Rezoning Transportation Analysis

Petition Number: 2023-027

From: Jake Carpenter, PE
Jacob.carpenter@charlottenc.gov
980-221-5675

Date	Description
06-28-23	First Review (PDM)
07-27-23	Second Review (PDM)
8-30-23	Third Review (JP)

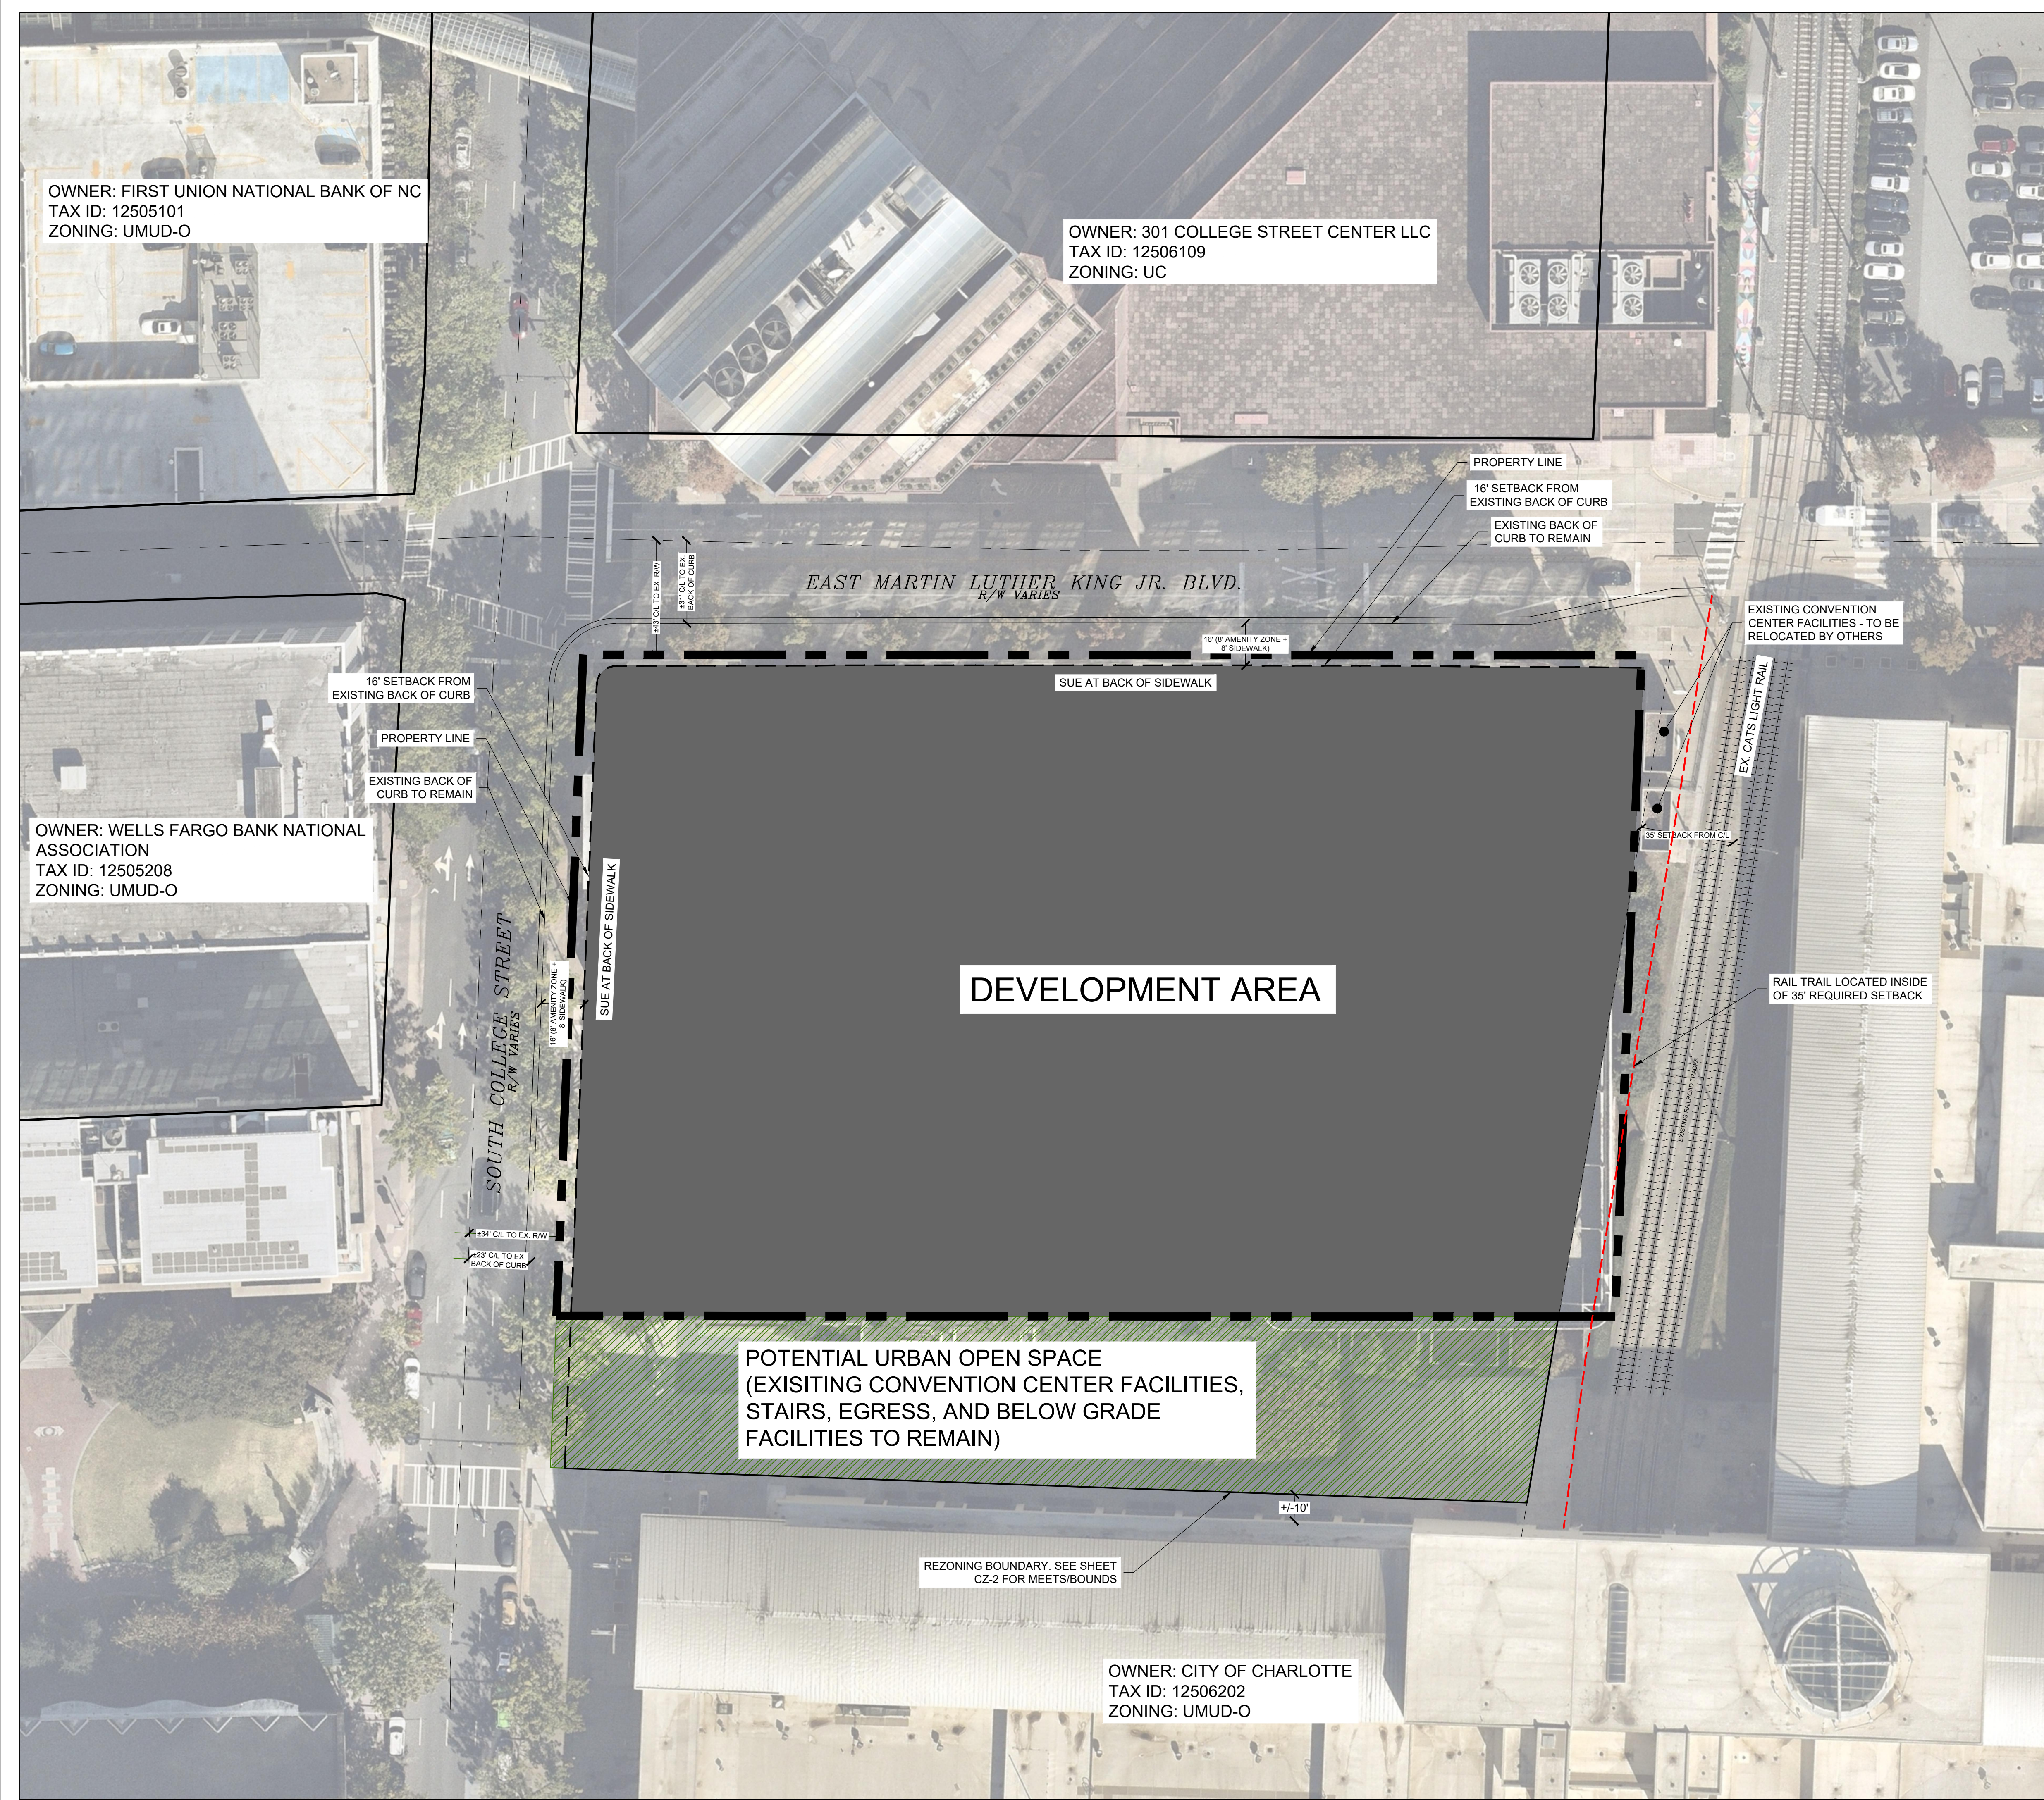
Revise site plan to add more clarity to the area below that is outside of the property line but part of the rezoning. Is this public ROW?

Remove callout and conditional note regarding relocation by others for construction of Rail Trail. This should be coordinated during the rezoning phase of the project.

Remove callout on site plan referencing relocation of convention center facilities by others.
